Final Acceptance Punchlist

El Paso County – Department of Public Works – Stormwater Section

Project Name:	Widefield Park & Rec Improvements
EDARP File Number(s):	PPR2213, CON2261, ASB2316
ESQCP Number:	ESQ2250
Attendees:	DPW SW: Ben Jones DPW Development Services: N/A Developer: David Gish, Nuun Construction, Todd Kimes (LKA Architects), Jim Houk
Date of Walk-through:	04/08/2026
Walk-through Number:	1st

C7.5

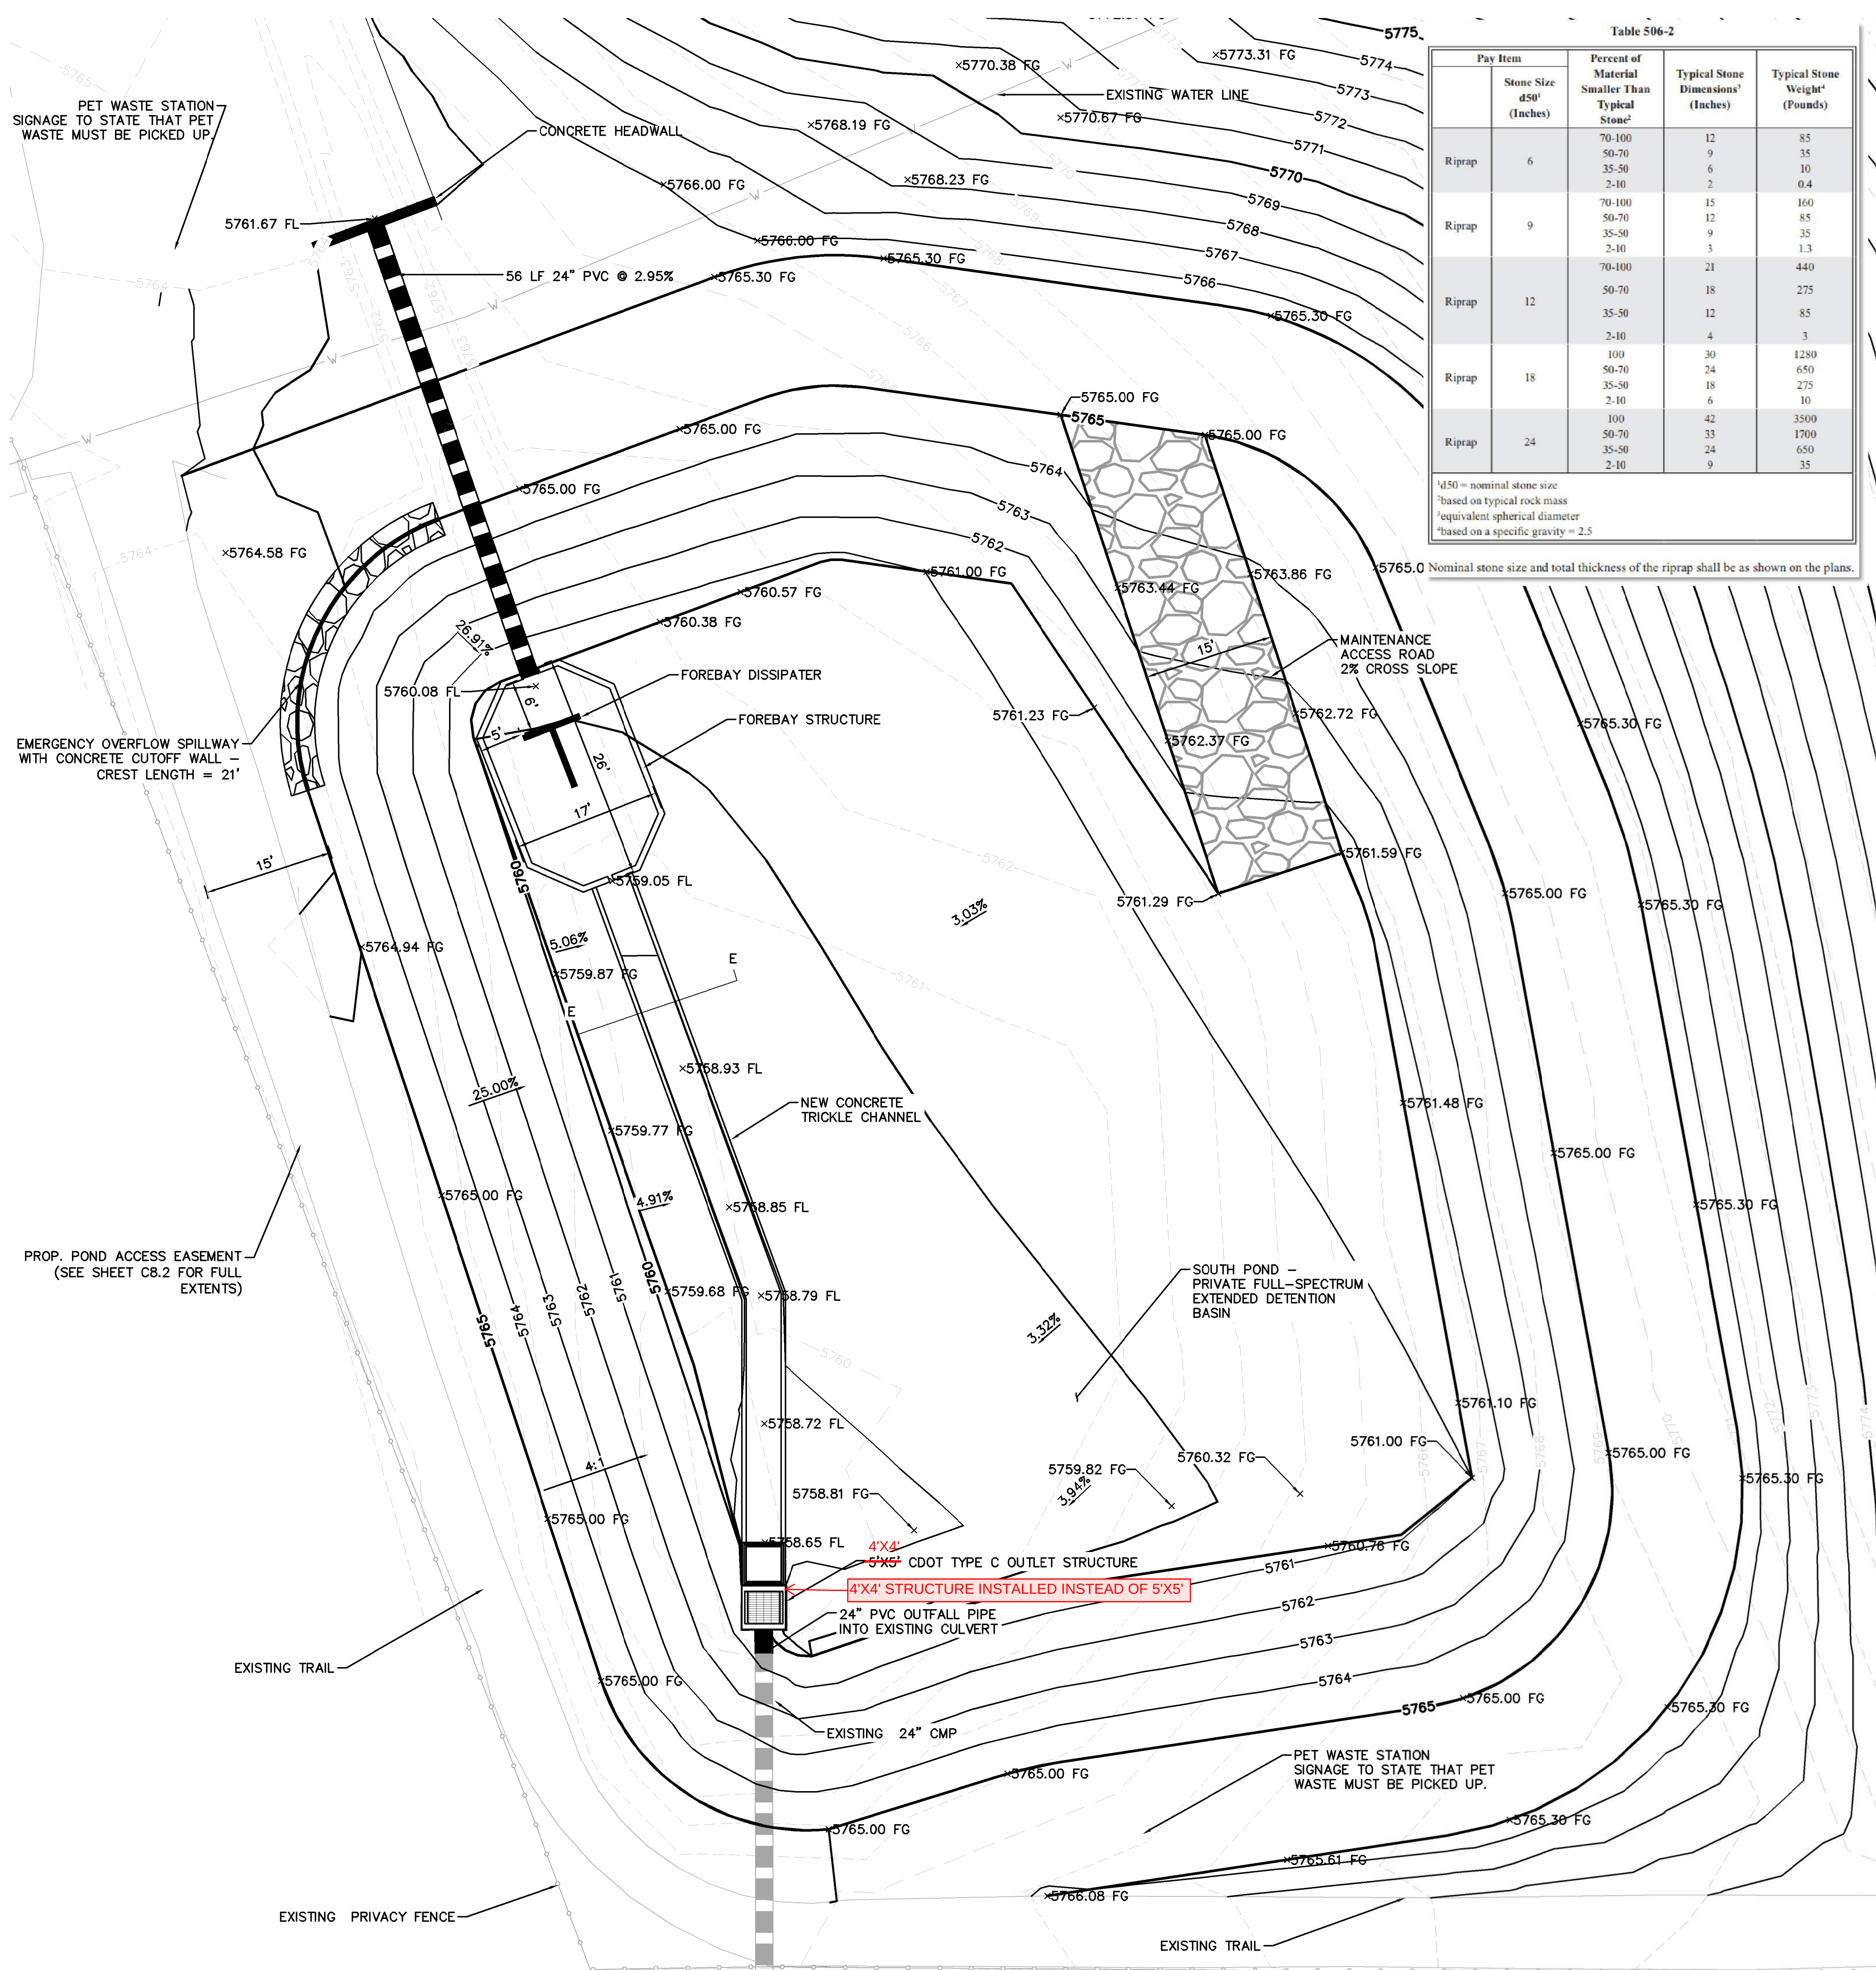
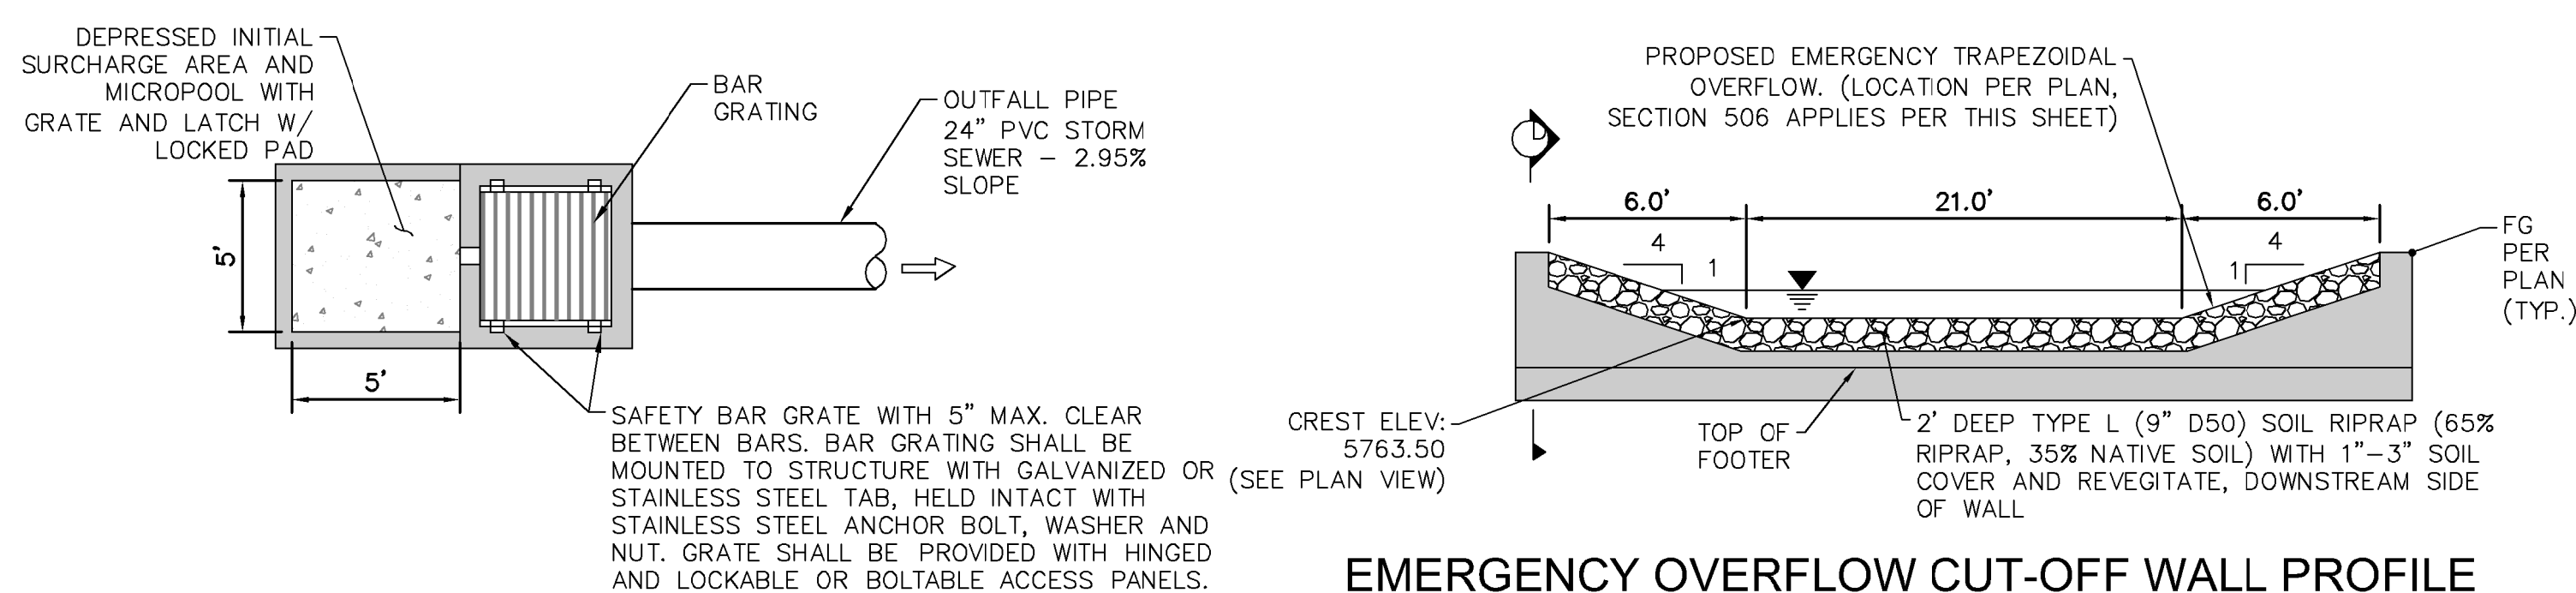
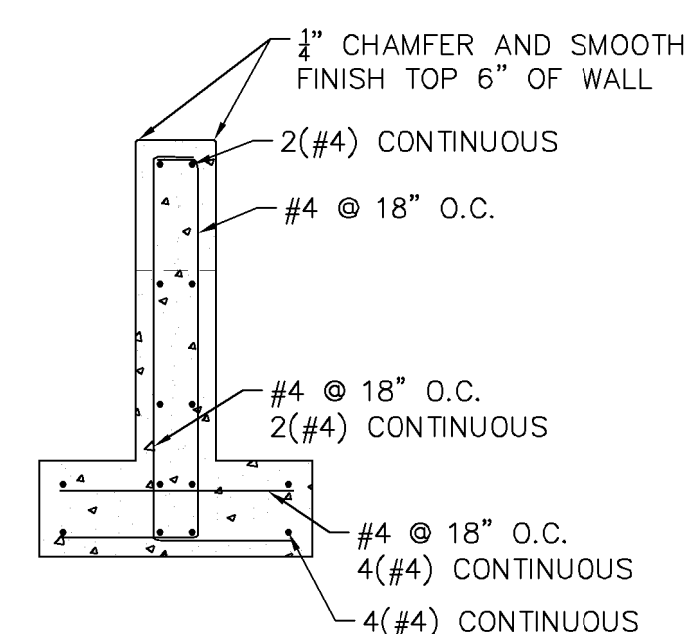
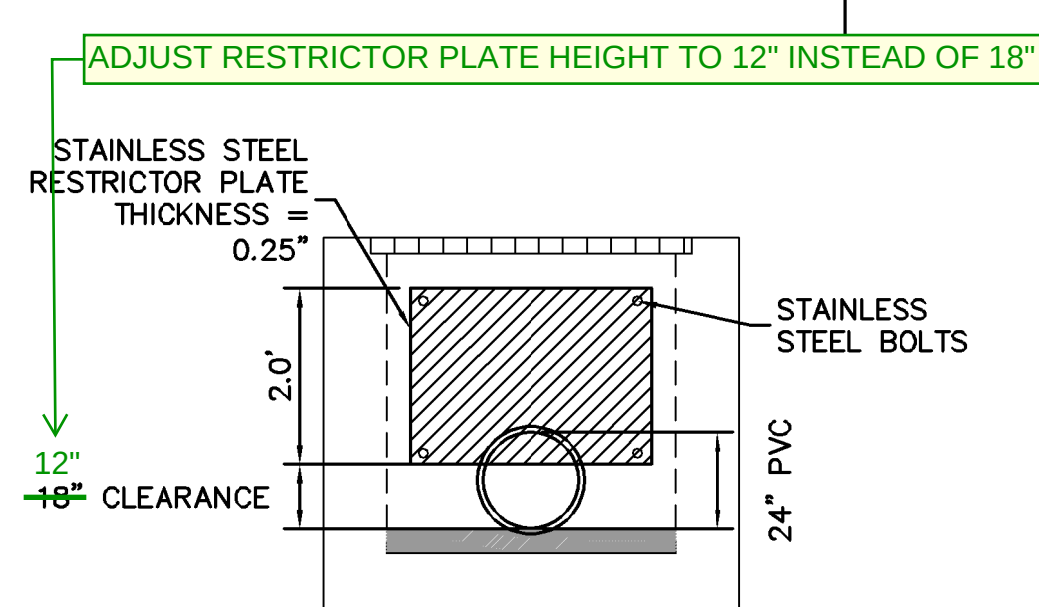
- Outlet Structure
 - Clean Trash Rack and repair lock mechanism. See photo 4.
 - Clean debris from Microscreen. Microscreen is a different material than called out on plans. Plans call for Johnson Vee Wire No. 93. Send updated detail on current screen material or replace per plans. See photo 5.

- Add concrete crossmember to top of outlet structure where missing between microscreen and orifice plate. See photo 6.
 - Orifice Plate Gasket is inadequate and needs to be replaced. Send updated detail on current gasket material or replace per plans. See photo 7.

- Microscreen material was welded to orifice plate. Remove material from orifice or consult Engineer of Record.
 - Restrictor plate measures 12 inches above outlet pipe invert. Plans call for six inches above outlet pipe invert.

KHA Response: McNichols perforated metal screen is an acceptable substitution.

KHA Response: Steel cross member solution proposed by the contractor is acceptable and outlet structure will function as hydraulically intended.

KHA Response: Restrictor Plate specified to restrict 6" from the top of pipe, not 6" clear, and was installed correctly. Refer to the Letter from the EOR confirming this condition.

C7.4

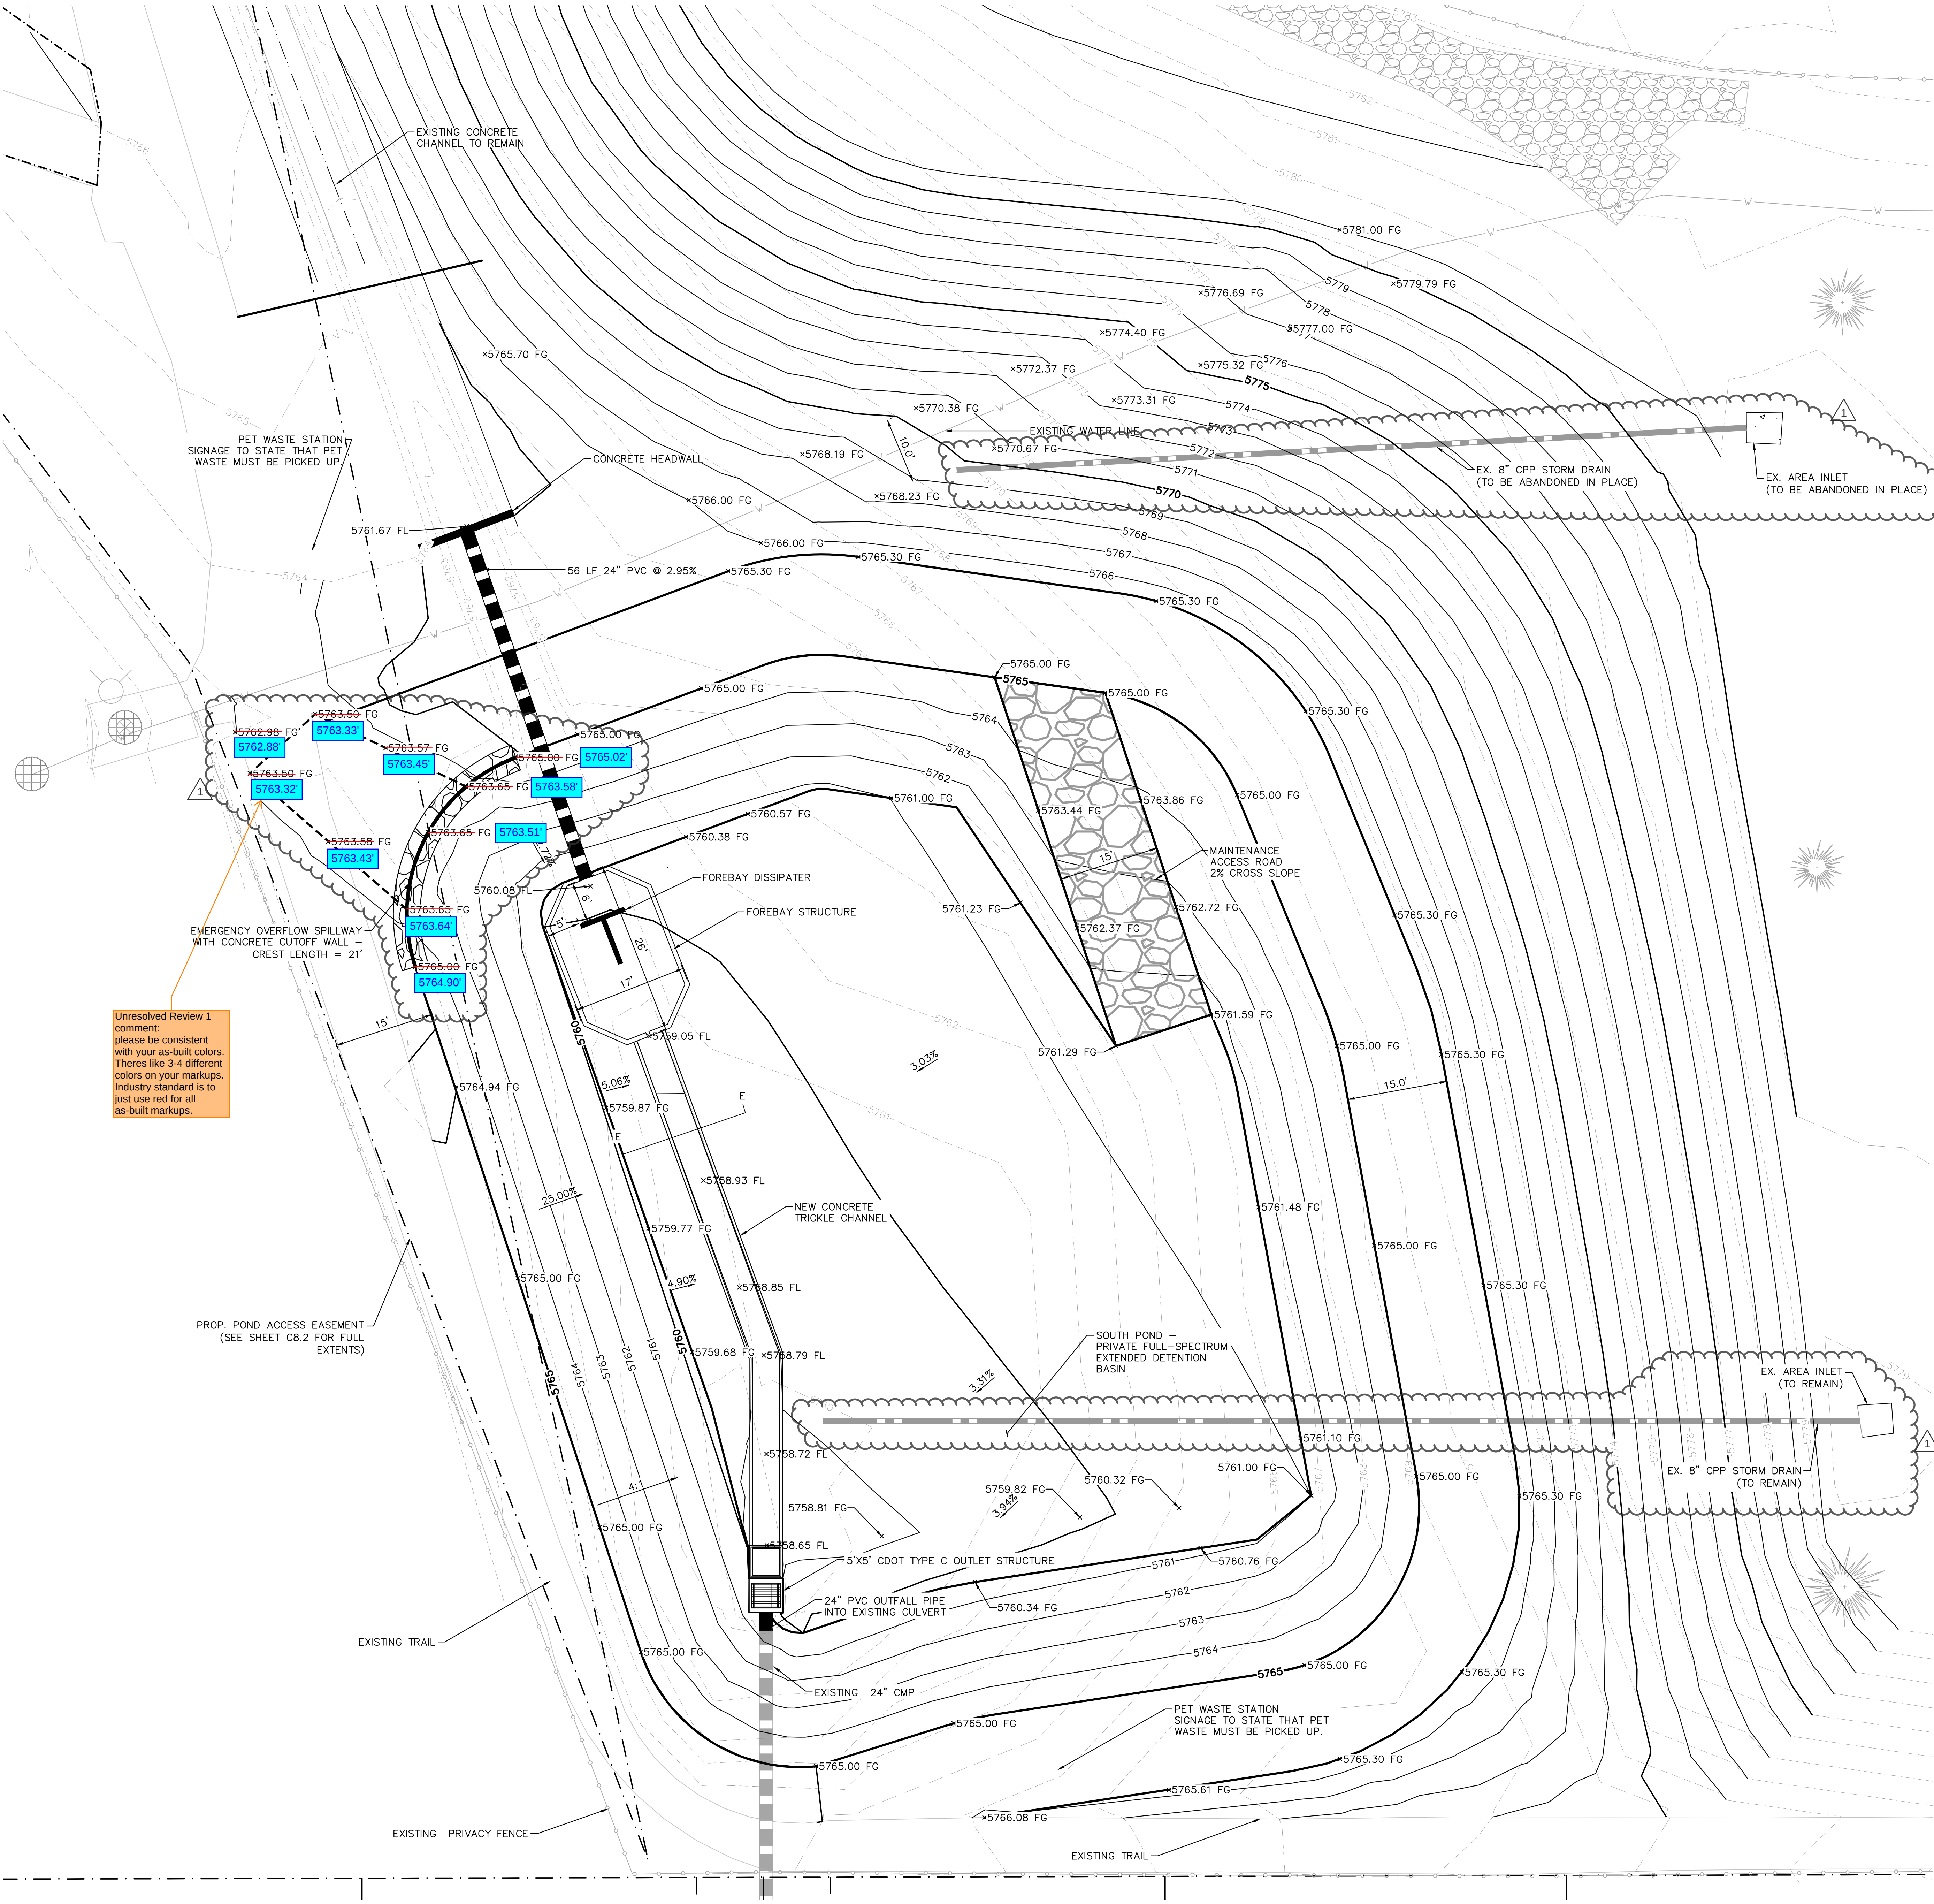
- Repair erosion on each side and stabilize. Consult Engineer of Record regarding installation of riprap at these two locations. See photo 2.
 - Clean out Drainage Ditch before pond Forebay. See photo 10.

- Emergency Spillway
 - Elevation of Emergency Spillway, show on as built.
- Area drains
 - 2 Inlet drains. South side above pond, show on as built.

KHA Response: Stabilization of erosion via rip rap is recommended.

KHA Response: Emergency spillway grading as-builts marked up on revision of the CD Sheet C7.4 (Pond Grading).

KHA Response: North area drain is filled with sediment and non-functional. North drain and associated pipe are to be abandoned in place. South area drain and pipe is functioning and will remain. A revision of the CD Sheet C7.4 (Pond Grading) has been reprinted showing these pipes for documentation purposes.
